BUILDING INSPECTION PERMIT

Permit Number: 041265

This is to certify that Drown Gretchen S &/Nate S lock
has permission to Renovate attic to bath, storage studio
install window staircase
AT 677 Ocean Ave 169 E002001

RE: 677 Ocean Avenue – CBL: 169-E-002 – R-5 Zone

DWG. #16
 Section Thru
 Attic Bathroom
 19 July 2004
 1/4" = 1'-0"

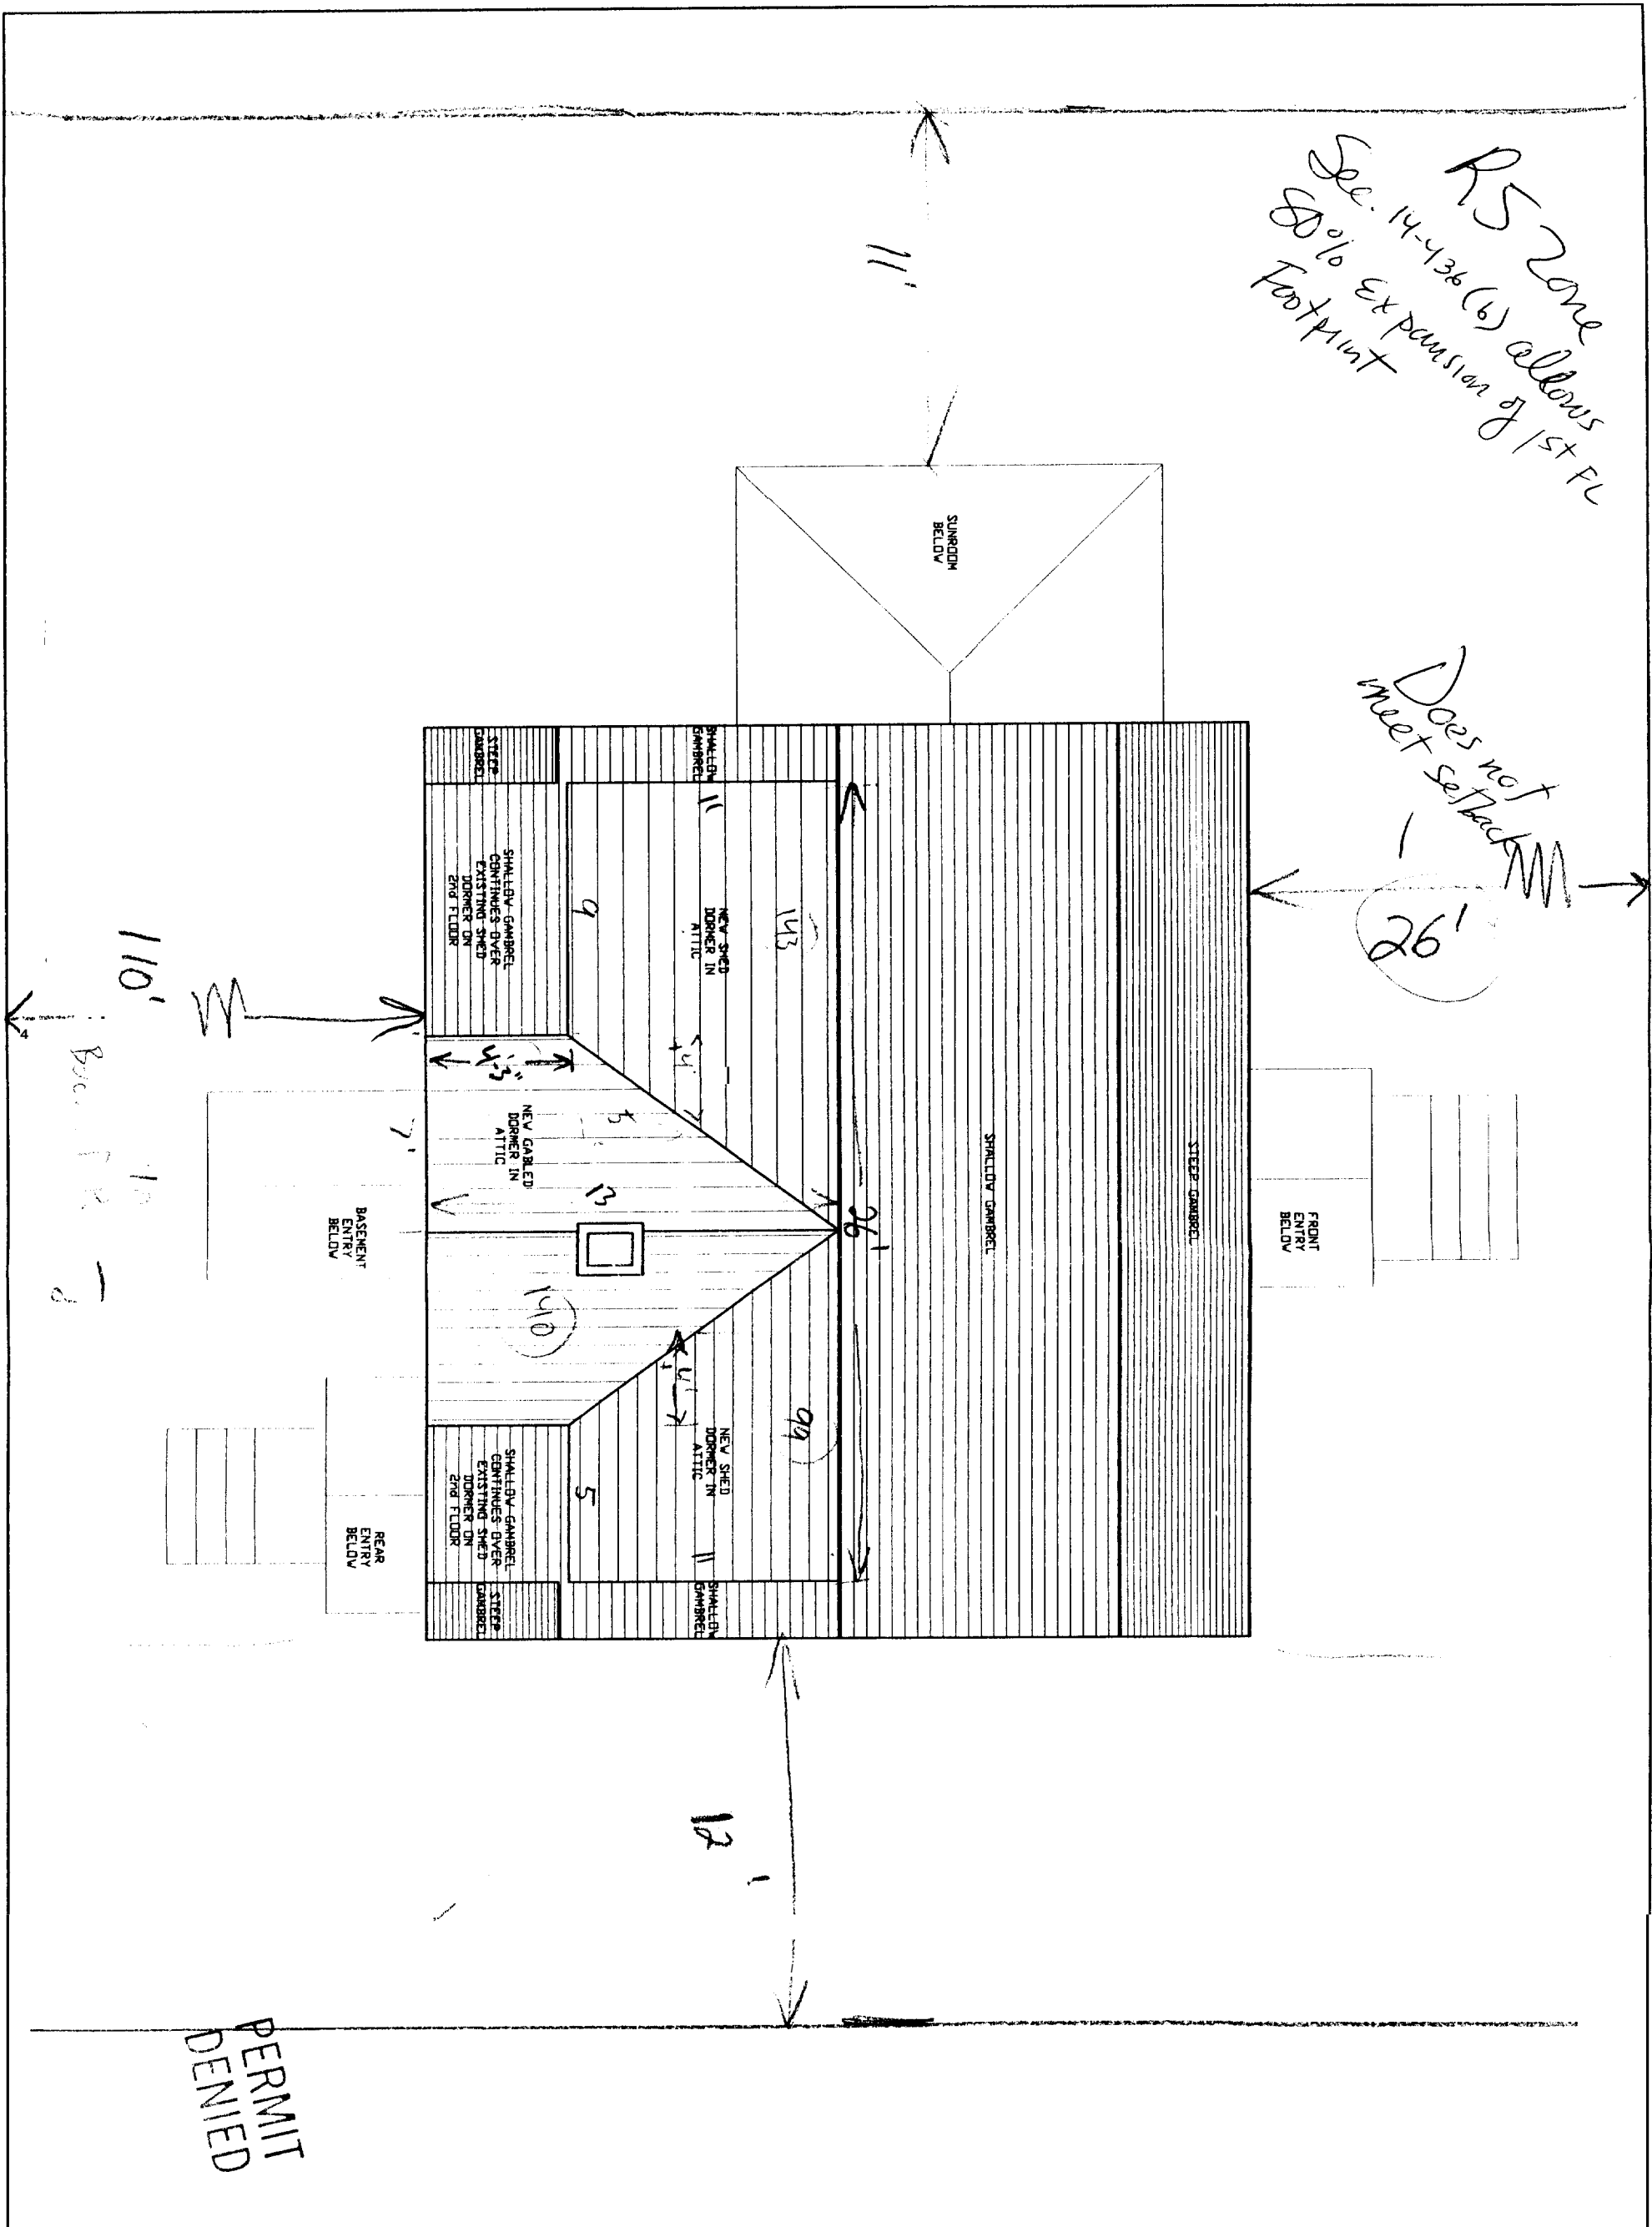
I am in receipt of your permit application to renovate the attic for a $\frac{3}{4}$ bath, studio & storage space. Your permit is being **denied** because the habitable space does not meet the required ceiling height.

Section 1204.1.2 of the 1999 BOCA Building Code refers to sloping ceilings. The 7-foot ceiling height for the room is required in one –half the area thereof. Any portion of the room measuring less than 5 feet from the finished floor to the finished ceiling shall not be included in the computation of the minimum area thereof.

With the measurement at the ridge being approximately 7'-2" and the ceiling height decreasing from that point, the required ceiling height is severely compromised. Due to this deficiency, this permit is being **denied**.
